Shivesh Singh - Online Submission from Paul Chilcott (other)

I make the following submission for the proposed changes for the 'Stabling Precinct' at Randwick Racecourse - MP10_0098, where I consider the traffic and access arrangements have not been adequately addressed in the application:

Submission for Job: #4092 MP10_0098 - Project Application for construction of new stable facilities
https://majorprojects.onhiive.com/index.pl?action=view_job&id=4092

Motion ? Racecourse ? stabling proposal, cnr Alison and Wansey Roads - MO10_0098

SITE PLAN
STABLES & TRAINING FACILITIES
AJC RANDWICK RACECOURSE

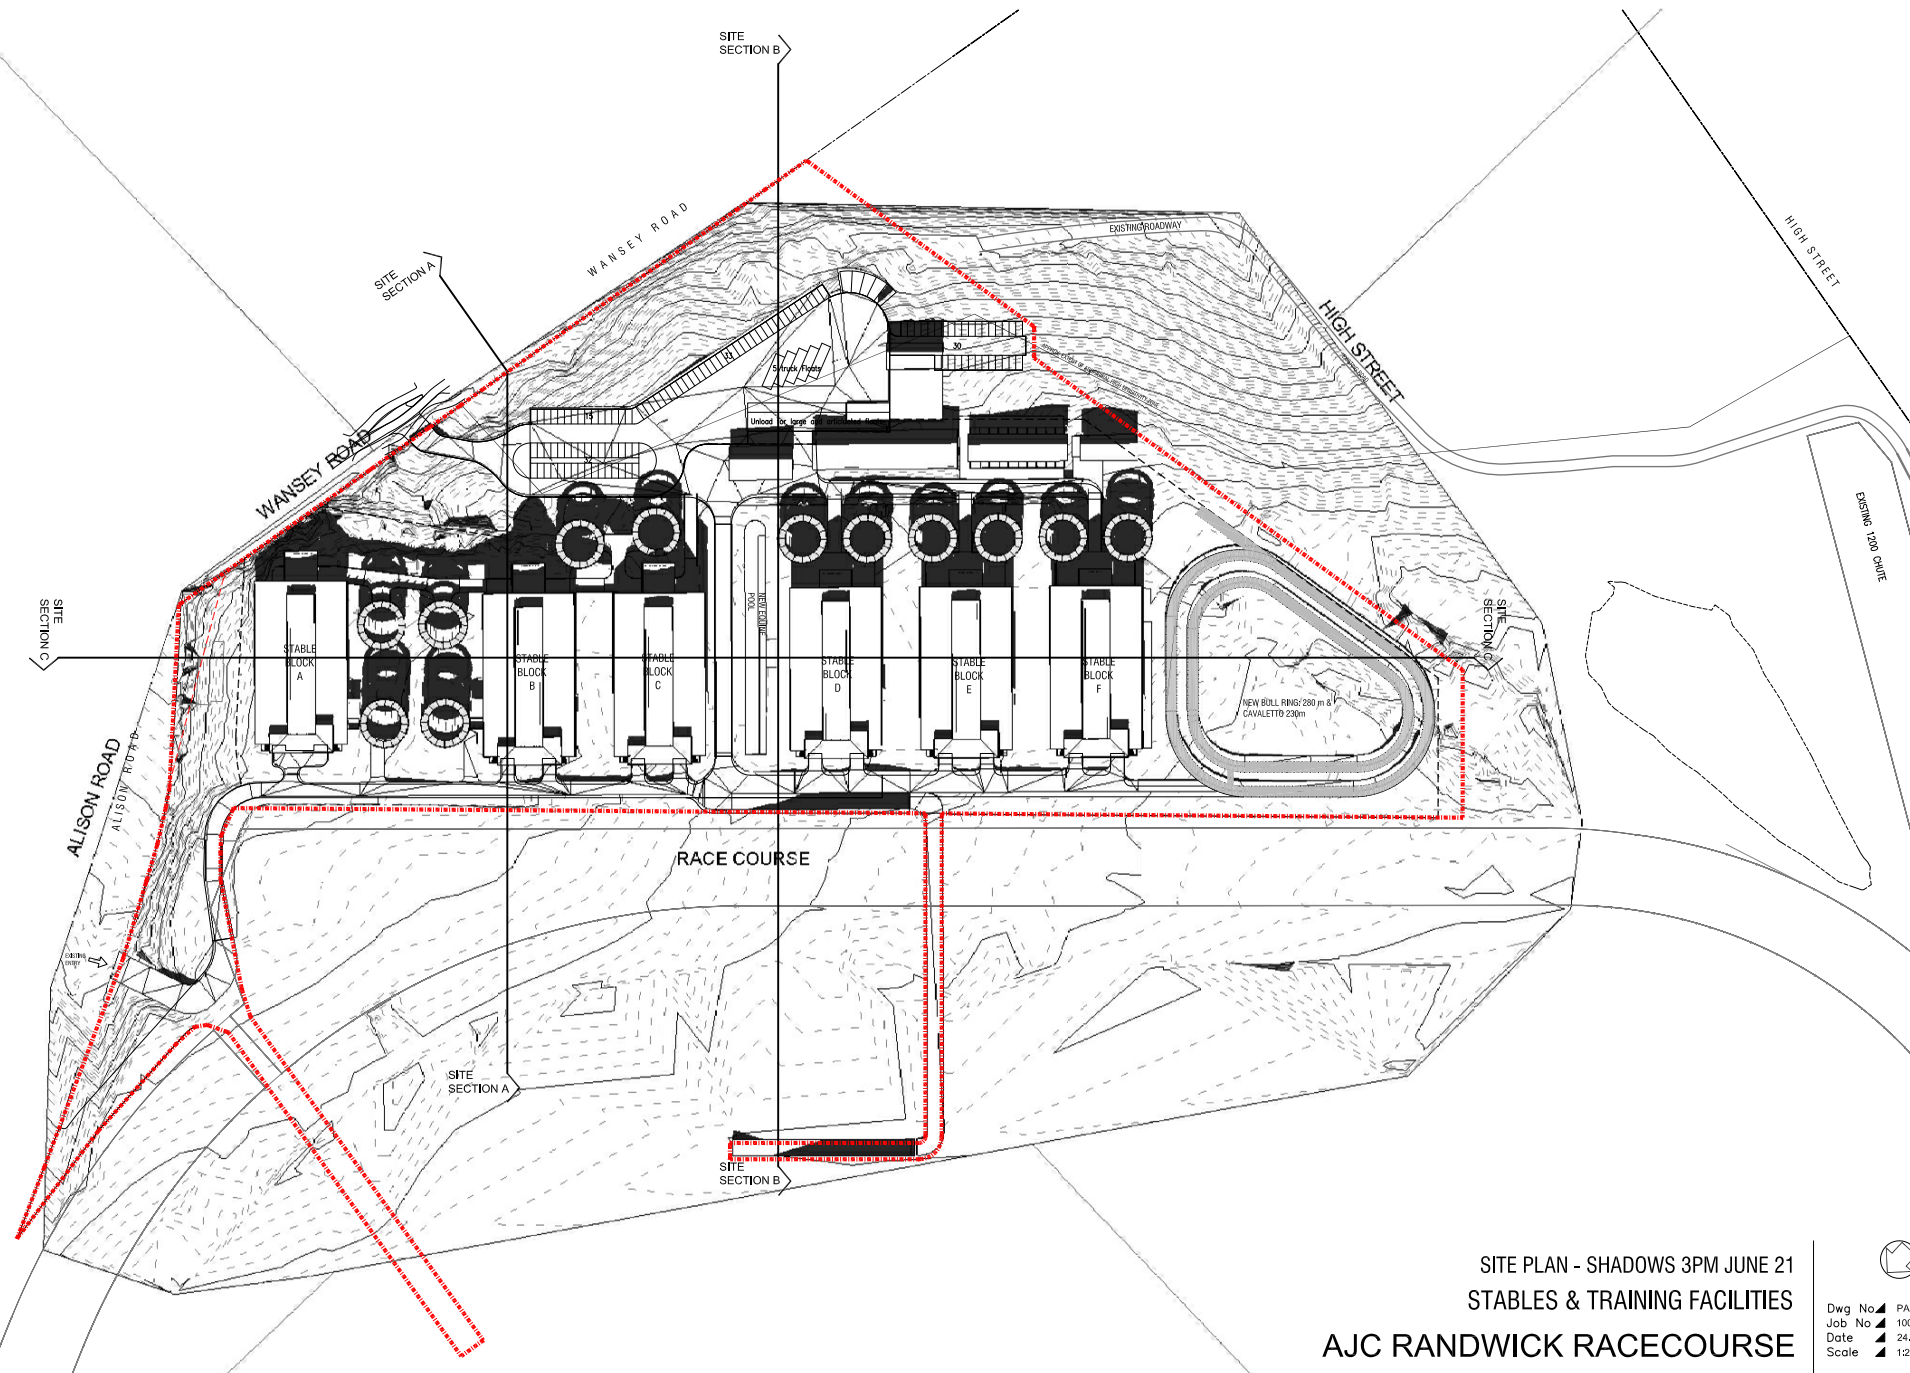
1. The moving of the gate northerly is welcomed, however, pedestrian & cyclist and traffic conflicts still exist.

2. The western footpath of Wansey Rd is part of a cycleway, which due to topography, leads to high speeds by cyclists heading north to Alison Rd. For this reason, I would suggest that requirement of vehicles giving way to pedestrians and cyclists on the footpath be reinforced at this location. For that reason, when entry or exit gates (or boomgates etc) are opened, a light should flash to alert cyclists and pedestrians to vehicles crossing the footpath. In addition, a security camera should be provided at this entrance so that access can be monitored via Racecourse management and to provide a reference in the event of any accidents etc.

3. If an entry gate for vehicles is to be provided, it should be recessed sufficiently into the site to allow at least one large vehicle to enter the site fully while waiting for the entry gate to open. This entry gate should be separated from the exit gate which should be located at the site boundary - see # 4 below. The design of the racecourse entry / exit on High Street (opposite gate 2 of Uni of NSW) provides a good example of appropriate access. It is suggested in peak periods that the entry gate be left open.

4. A major issue with the current access is the ramp with a steep incline from the racecourse to Wansey Road. This means large vehicles are reluctant to stop when exiting as they lose momentum. An area level with Wansey Road should be provided to allow vehicles to wait and while the exit gate is opening to check carefully before crossing the footpath and turning onto Wansey Rd.

5. A pedestrian access into the site should be provided, separated from the vehicle access. Accesses by large vehicles should be limited to certain hours of operation, a restriction on large vehicles entering or exiting the racecourse between 9pm to 6am would seem to be a reasonable compromise between commercial requirements and residential amenity.

8. All exits from the Stabling Precinct should be left onto Wansey Rd and then left into Alison Rd. Any movements to other areas of the racecourse should be within the boundaries of the racecourse itself or, when from the Stabling

Precinct be via Alison Rd, Doncaster Avenue, Anzac Parade, High Street - not by turning right (south) on Wansey Rd. To reinforce this and to improve sightlines for vehicles exiting onto Wansey Rd, a kerb extension should be provided on the western side of Wansey Rd, south of the vehicle exit. Some consideration of a median island in Wansey Rd, opposite the exit gate to further reinforce the requirement for left only exits onto Wansey Road.

9. All entry, for large vehicles, to the Stabling Precinct should be via Alison Road into Wansey Rd and then right into the racecourse. To better account for general traffic thoroughfare south-east on Alison Rd, a turning lane in Alison Road into Wansey Avenue should be provided - the lane space exists, it's a matter of realigning the current traffic median in Alison Road.

It is also mentioned that a further median strip in Wansey Road, south of the entry gate may sufficiently narrow the turning capacity of large vehicles to turn left into the entry gate, to reinforce the need all large vehicle access from Alison Road. In conjunction with the comments made in point #8, a median strip in Wansey Road, both sides of the entry / exit gate with just a sufficient gap for vehicle entry from the southern side of Wansey Road, right into the Stabling Precinct should be considered.

10. To facilitate the movement of vehicles from Wansey Rd, particularly in the event of delay in entering the Stabling Precinct and being mindful of through south-bound traffic on Wansey Road, parking should not be permitted on the eastern side of Wansey Road, from Alison Road, up to the entry gate during the period that large vehicles may enter the site - following the comments made at point #5 above, between 6am to 9pm.

Regarding the existing plan for access from Wansey Road, we note the plans indicate a 'right in' and 'left out' movement for all vehicles on Wansey Road, including large vehicles. However the proposal does not provide details on how this will be implemented.
